DRB Application No.: 06DRB-00789 (SBP)

Project Name: Kingdom Hall of Jehovahs

**DEVELOPMENT REVIEW BOARD
TRANSPORTATION DEVELOPMENT
Standard Comment Sheet**

**CITY OF ALBUQUERQUE
PLANNING DEPARTMENT
June 14, 2006
DRB Comments**

SHEET TITLE
SITE DEVELOPMENT PLAN FOR BUILDING PERMIT

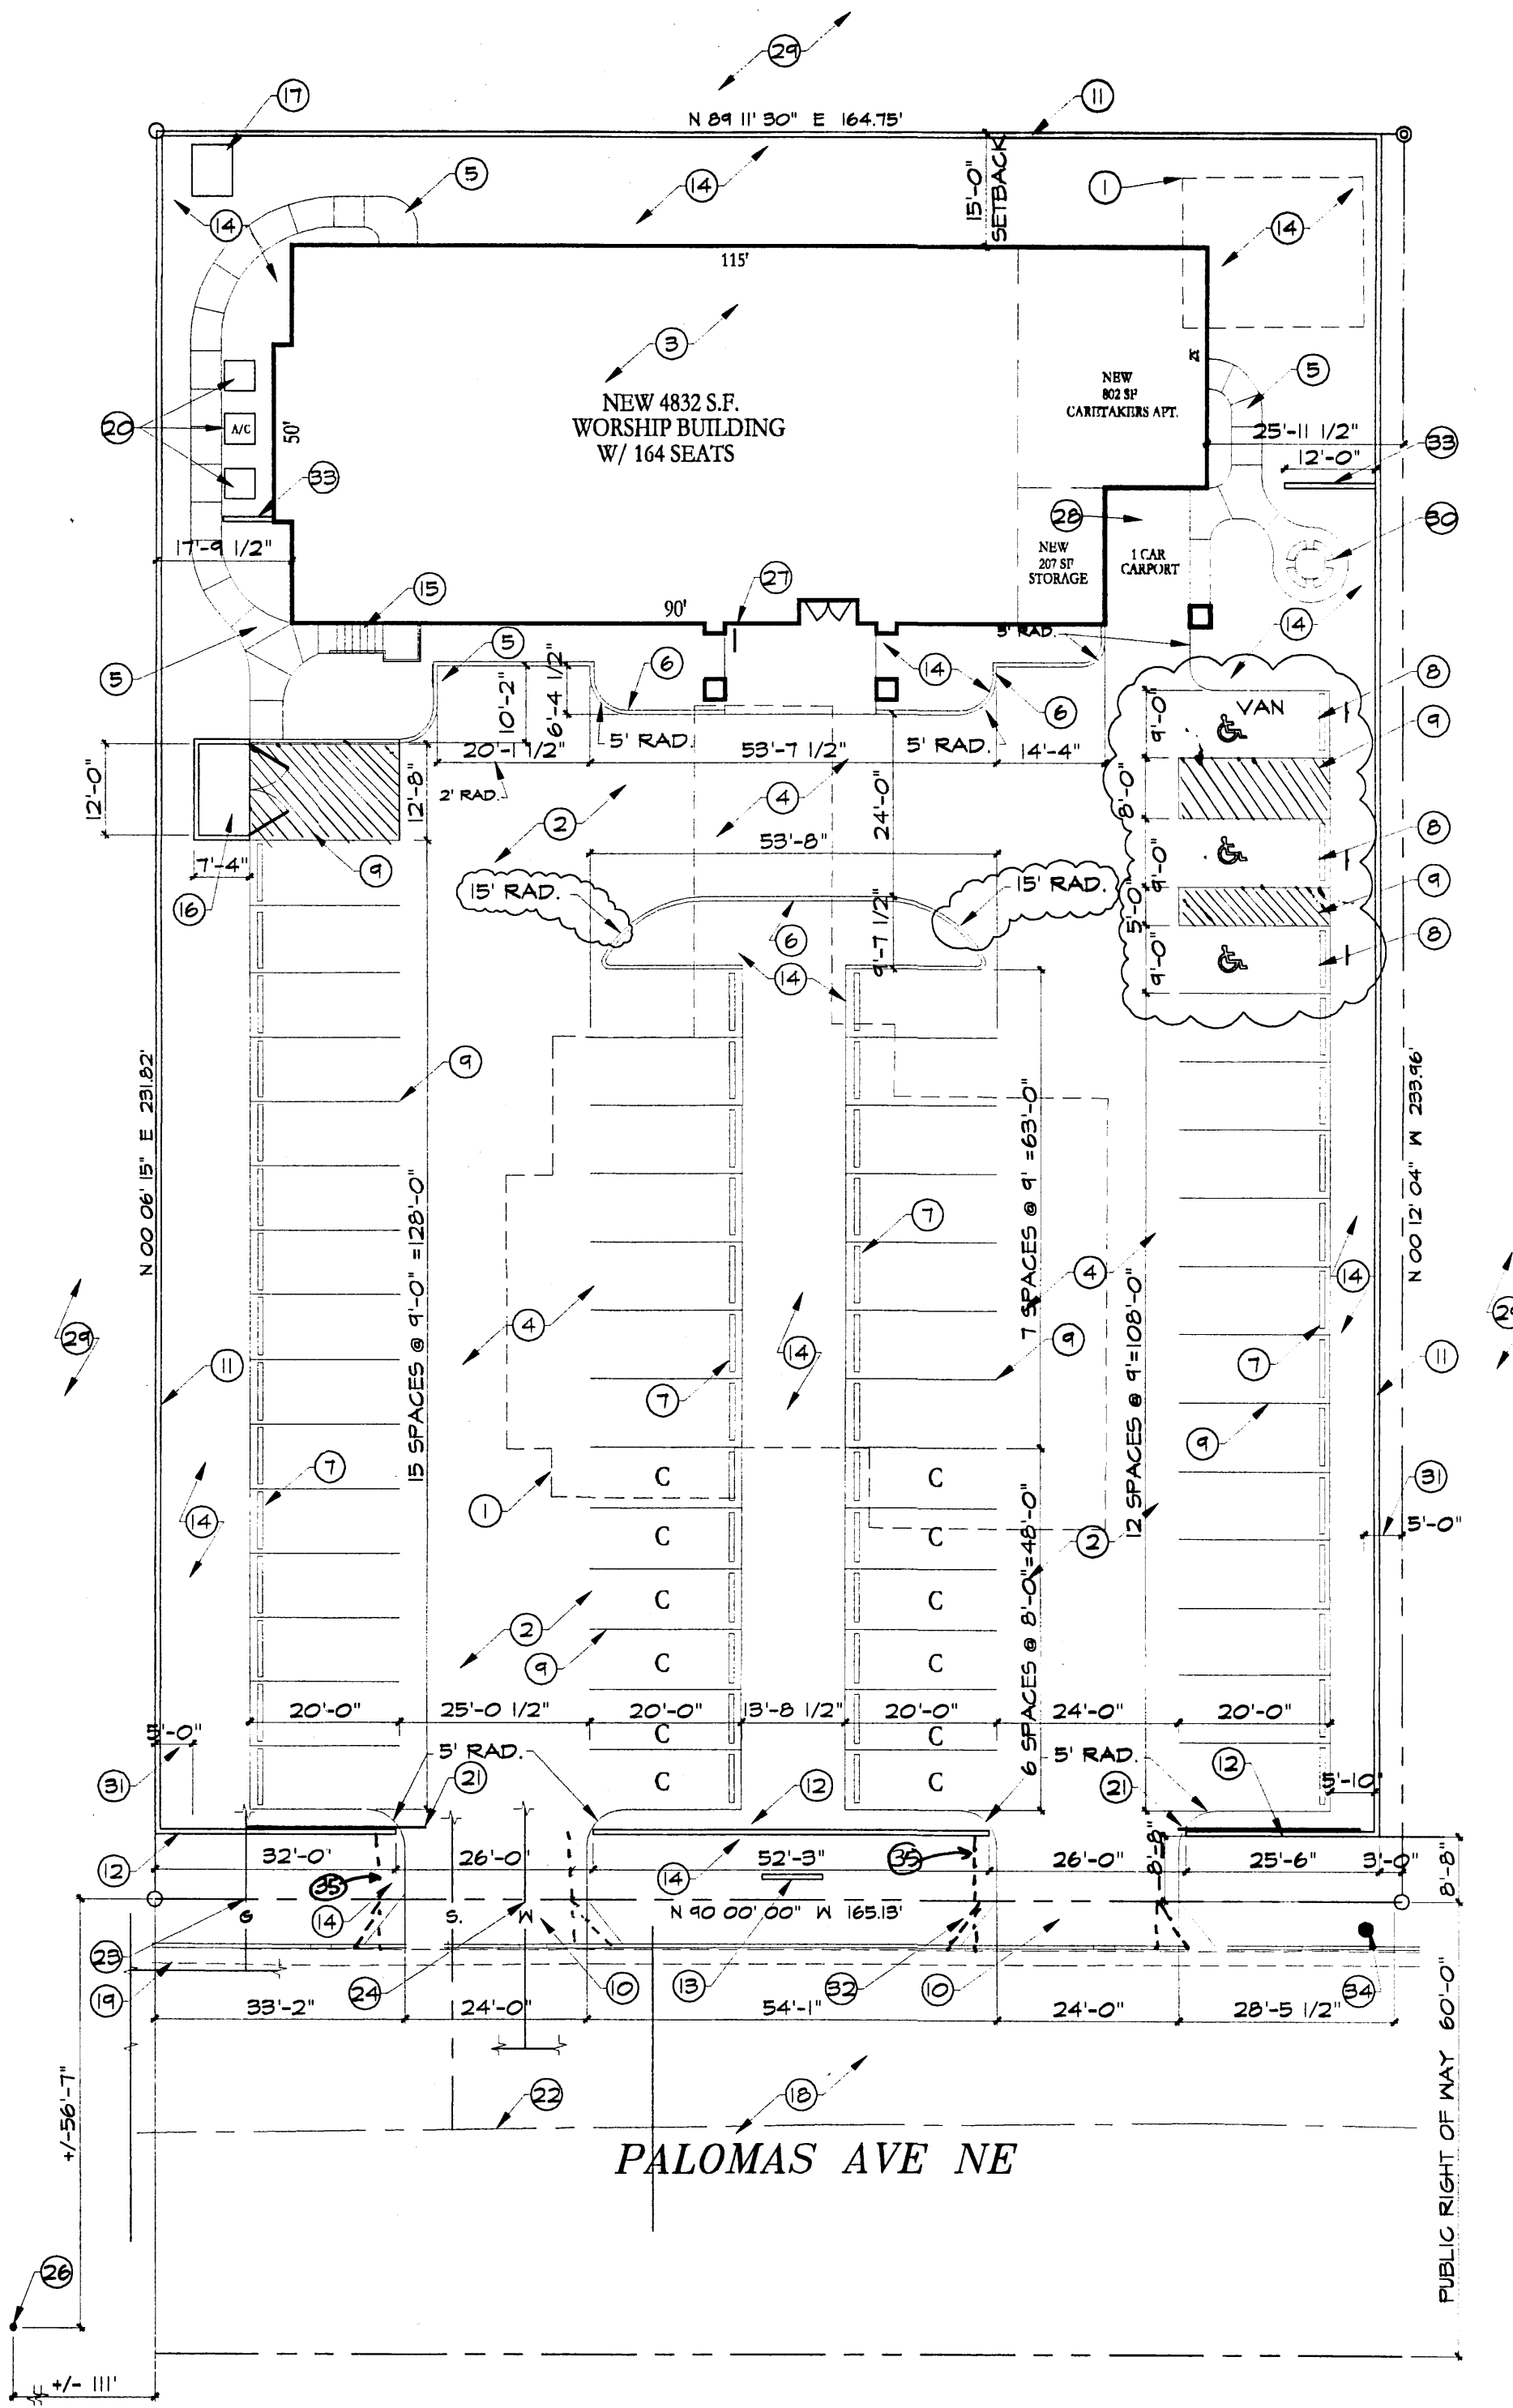
<u>No.</u>	<u>Comment</u>
1)	Applicant should provide a picture to verify that the Palomas improvements are permanent.
2)	Work within City right-of-way needs to follow City Standards. Where are the references to the City Standard Drawings?
3)	Why isn't there a van accessible ADA stall?
4)	The other ADA stall needs to have a 5' wide striped area.
5)	How is ADA being handled at the new curb cuts?
6)	End island radii need to be 15'.
7)	How is clear sight onto Palomas being met with the proposed wall? (need ~ 250')

Title Block should read "Site Development Plan for Building Permit".

Wall design is required for the walls on Palomas.

The existing zoning is RD, please remove the remaining zoning.

SHEET NO.: L-1

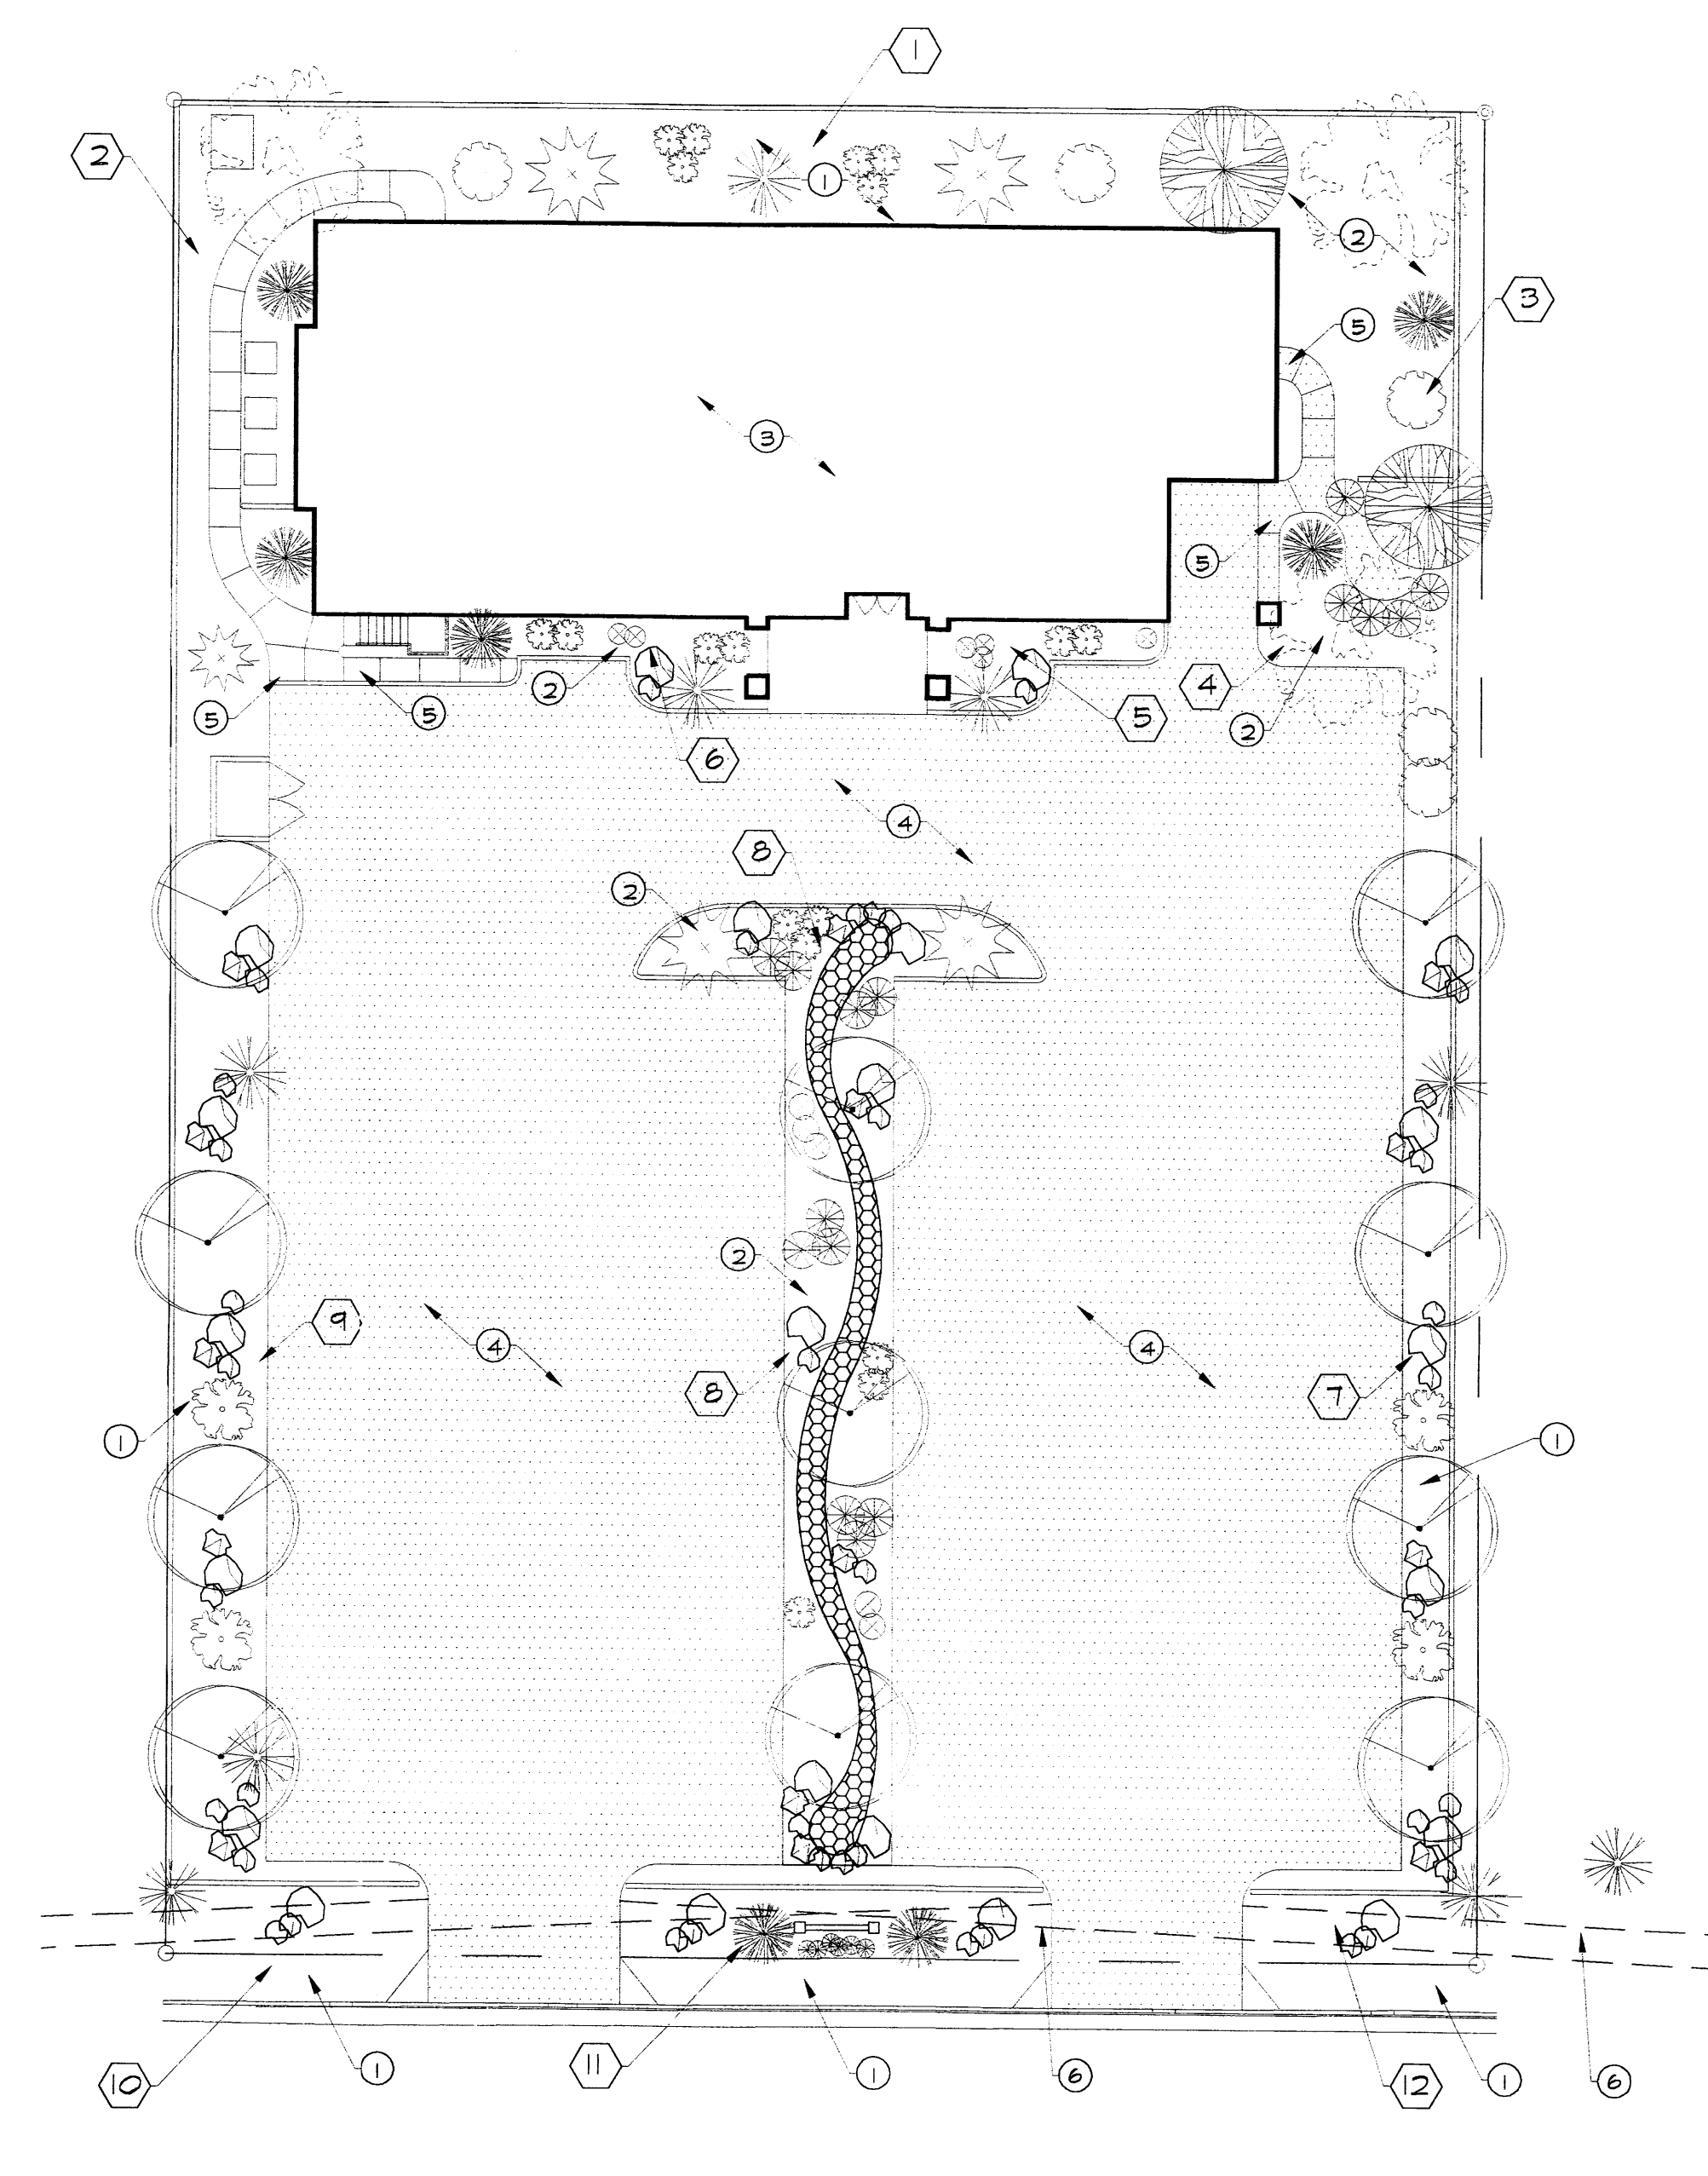
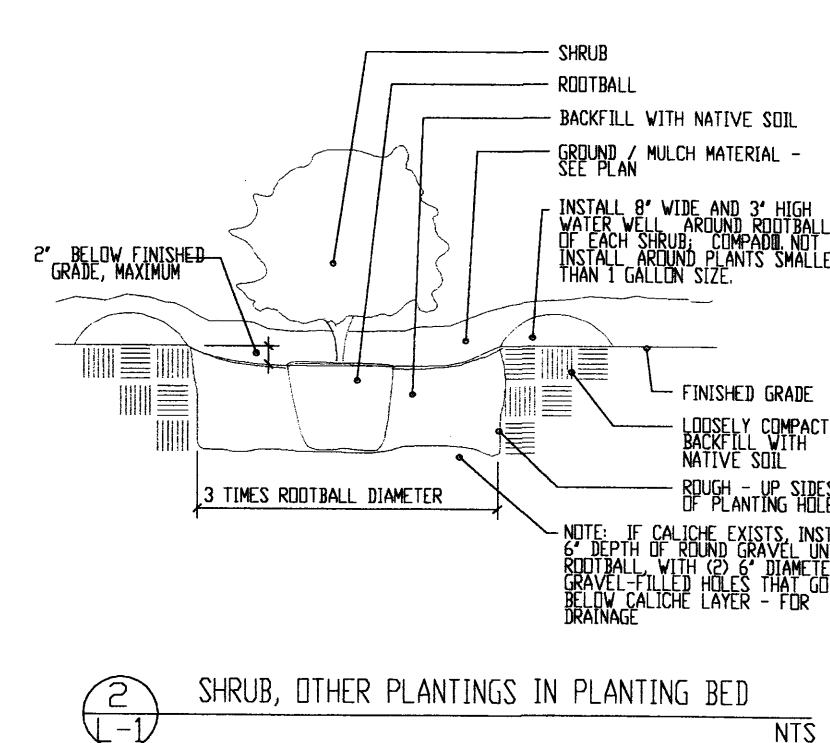
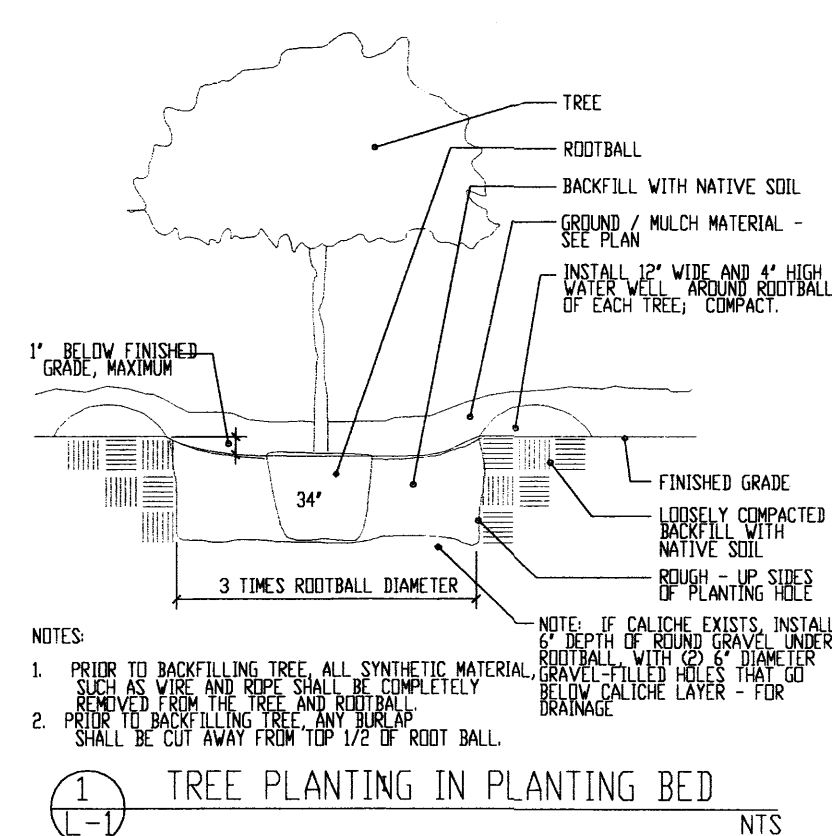
The landscape plan is missing some required statements.

The type of irrigation system is missing on the landscape plan.
